About the application

Application number: 2024/93520	
What is the application for?:	Prior notification for single storey rear extension
Address of the site or building:	24, Smithy Close, Skelmanthorpe, Huddersfield, HD8 9DQ
Postcode:	HD8 9DQ

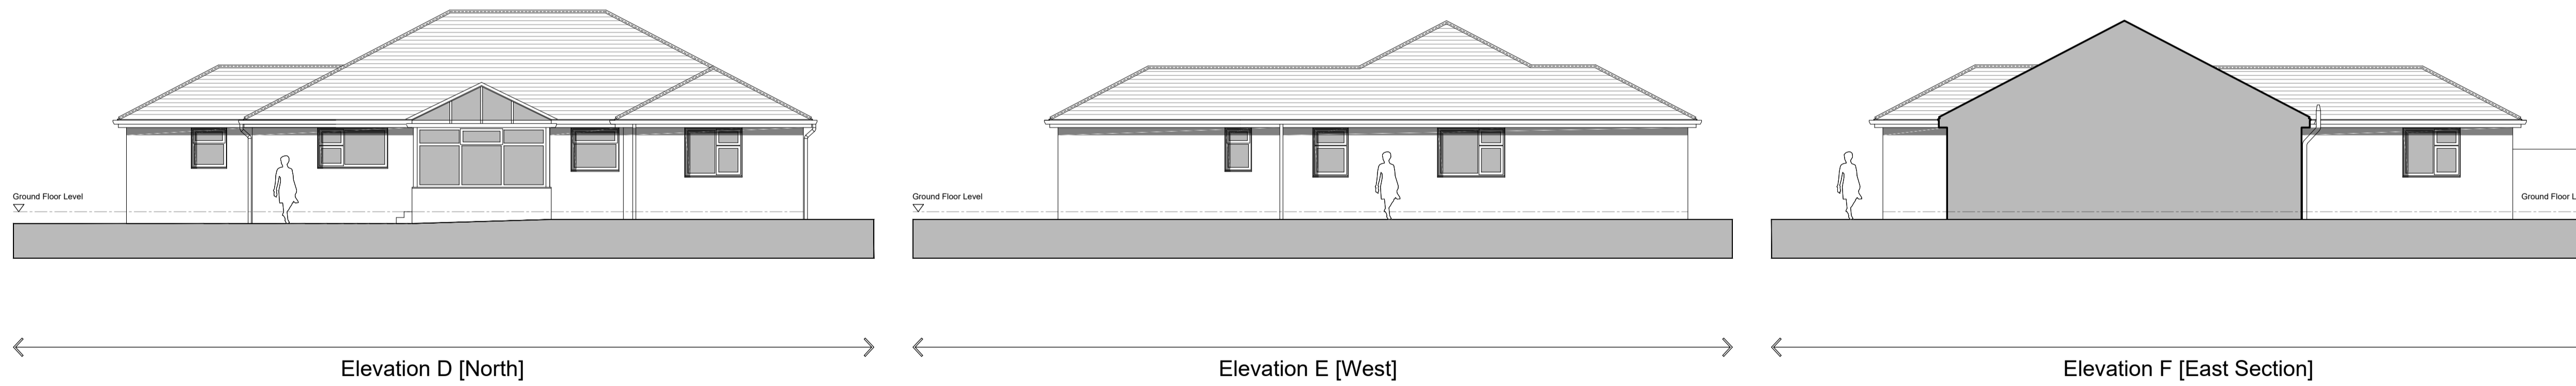
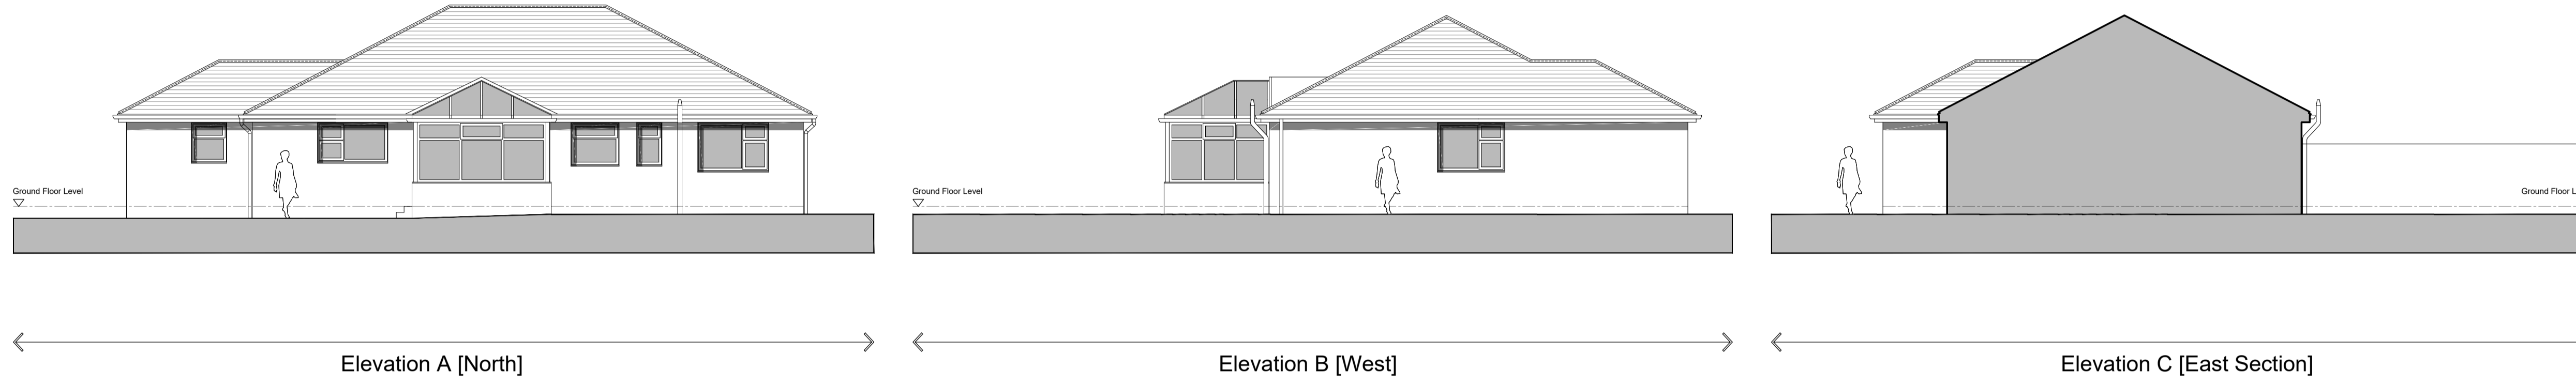
Type of comment: An objection	
Do you wish your comments to be published on the website anonymously?	Yes
At present I am objecting pending futher information. I feel that the slope of the land away from the rear of the property has not been taken into consideration and will result in the height of the extension above ground being significantly greater than stated when considered at the extension limit furthest from the property. This in turn will impact adjacent properties.
